REQUEST

Current Zoning: N1-A (neighborhood 1-A)
Proposed Zoning: UR-2(CD) (urban residential, conditional)

Approximately 9.23 acres located on the east side of Mallard Creek Road, north of Galloway Road, and west of Tavernay Parkway.

The petition proposes a residential community of up to 72 multi-family attached townhome style dwelling units together with accessory uses.

**RZ-2**

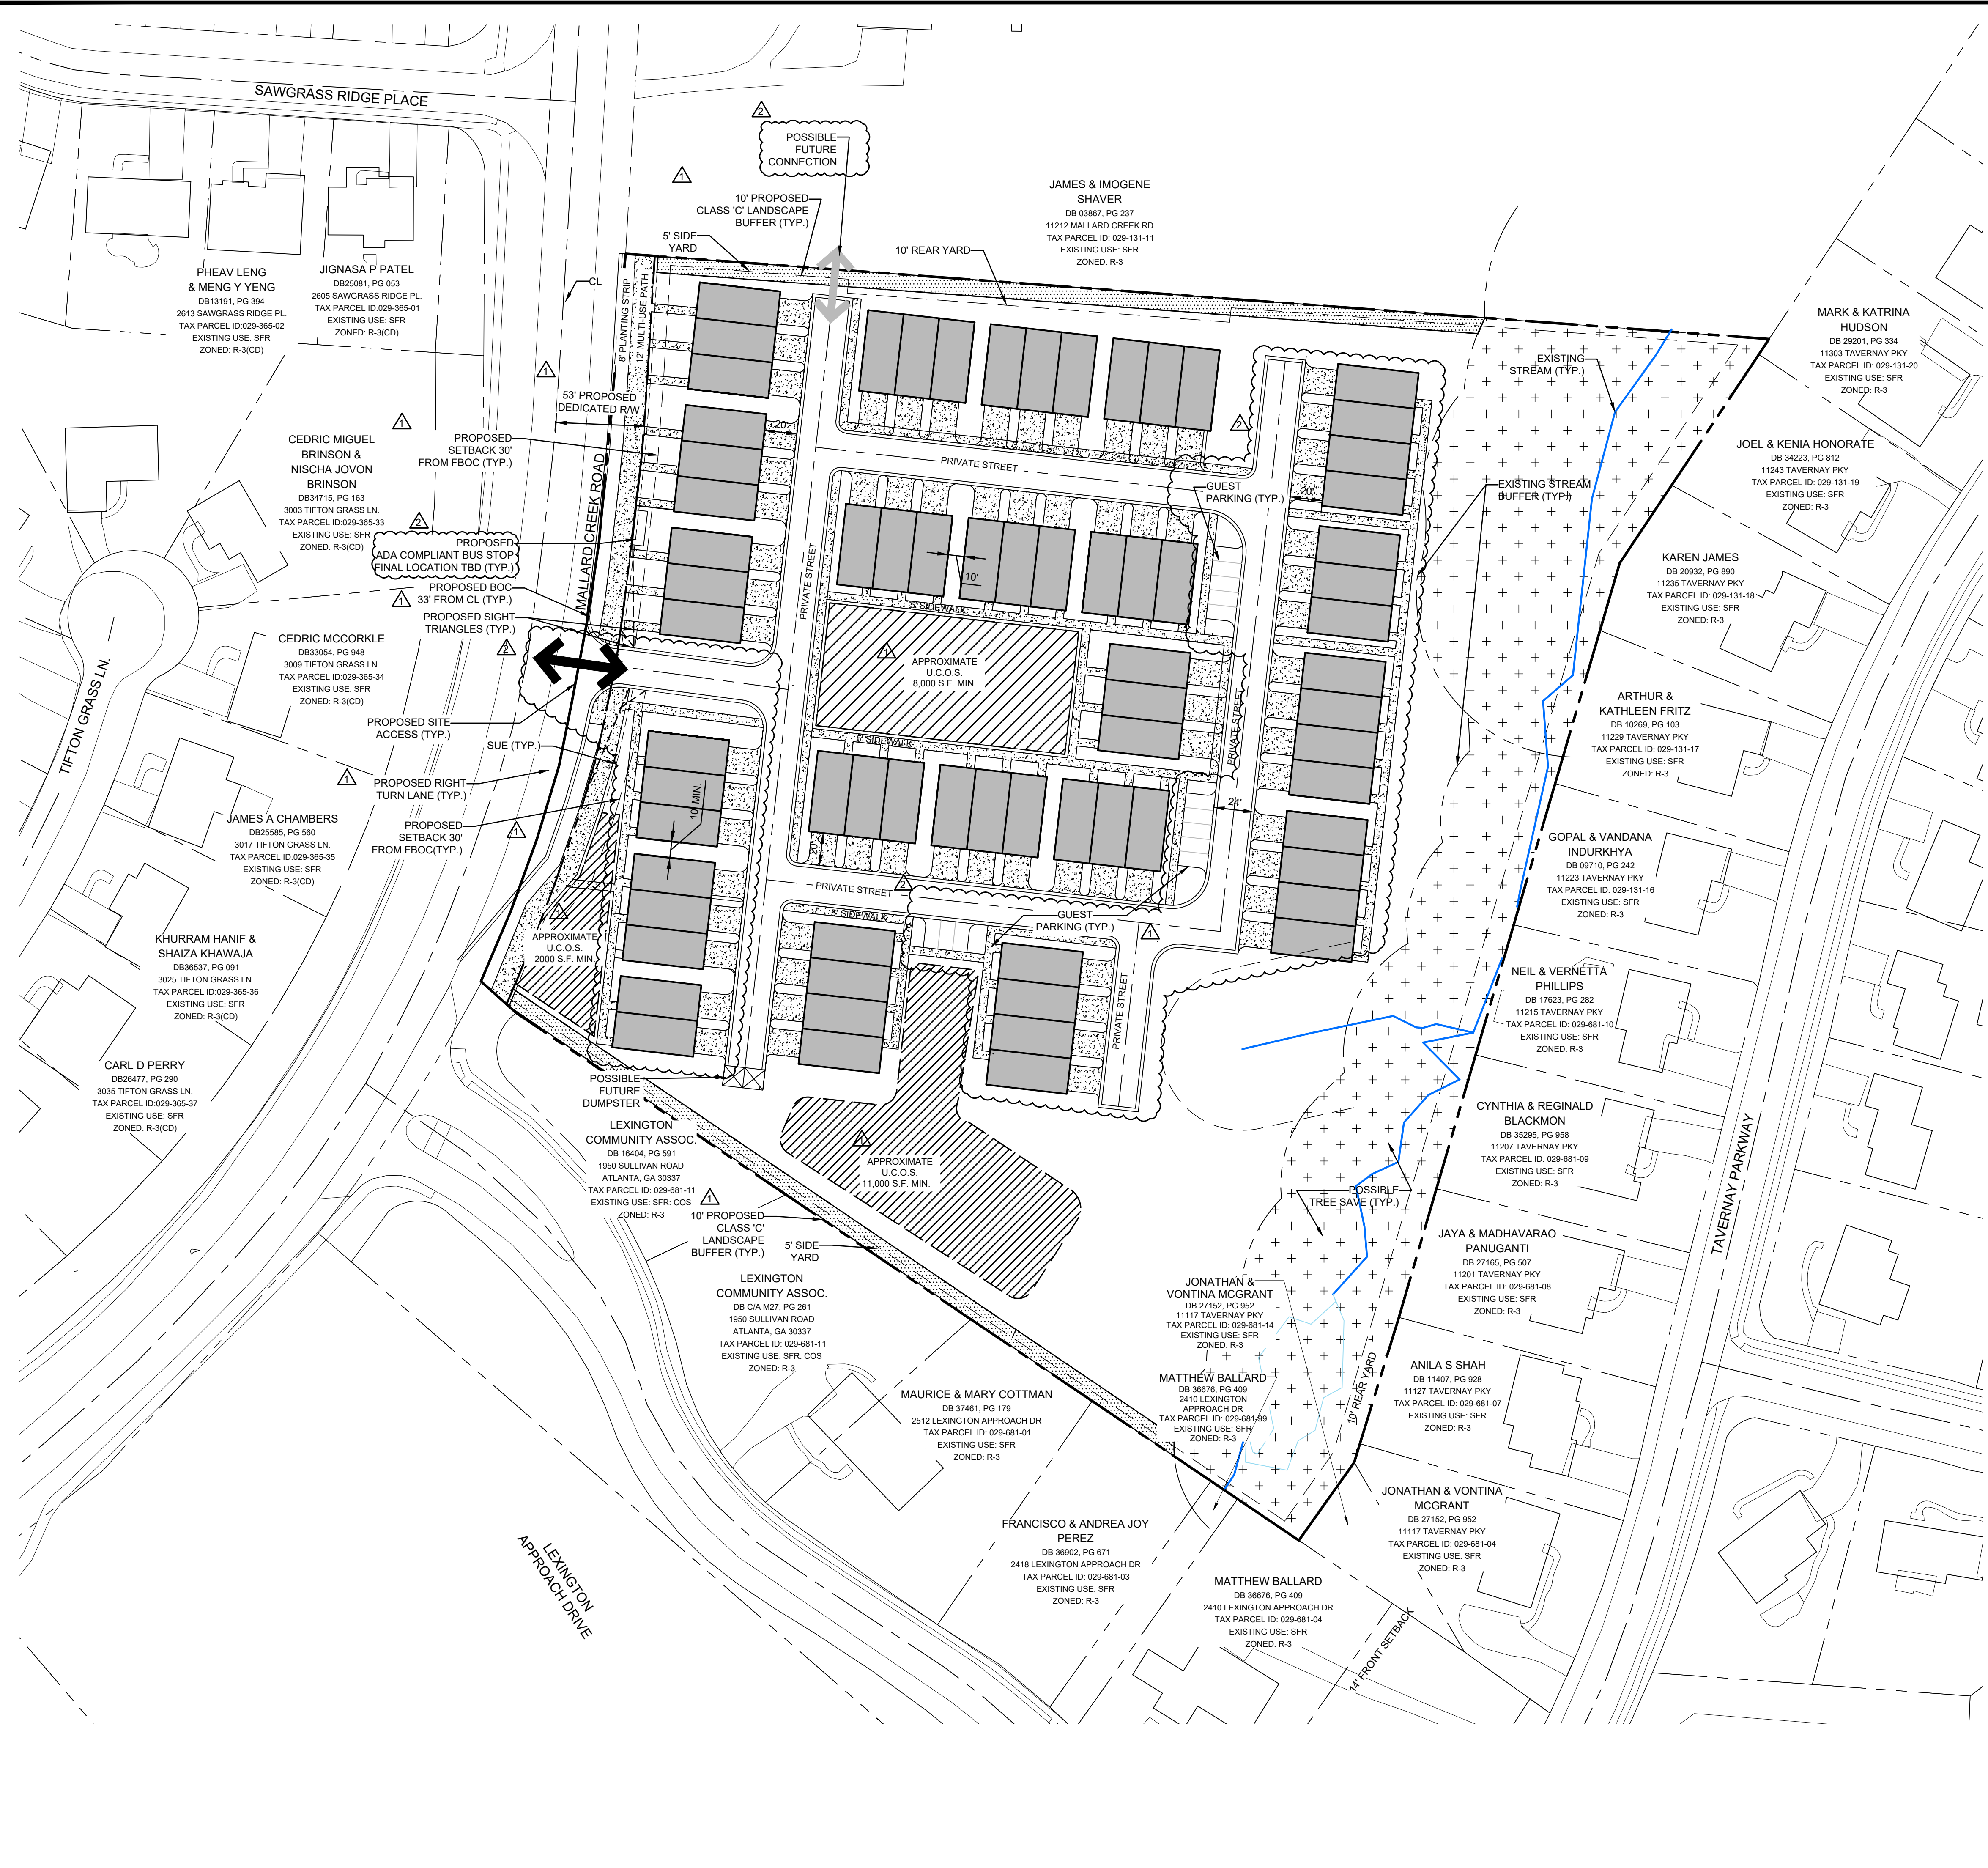
1. The site is served by CATS bus route #54. CATS requests the construction of ADA compliant bus standard detail 60.02A, 50 feet beyond the development entrance. The final location will be coordinated with the developer during the Land Development plan review process.
2. Site and Building Design
3. Reduce unit count and number of buildings with a mix of single family, duplexes, and triplexes to be consistent with the Neighborhood 1 Place Type.
4. Limit architectural note 5 to a maximum of 3 units per building along Mallard Creek Road.
5. Provide visitor parking spaces.
6. Limit height to 40-feet.
7. Add a street connection to the parcel to the north.
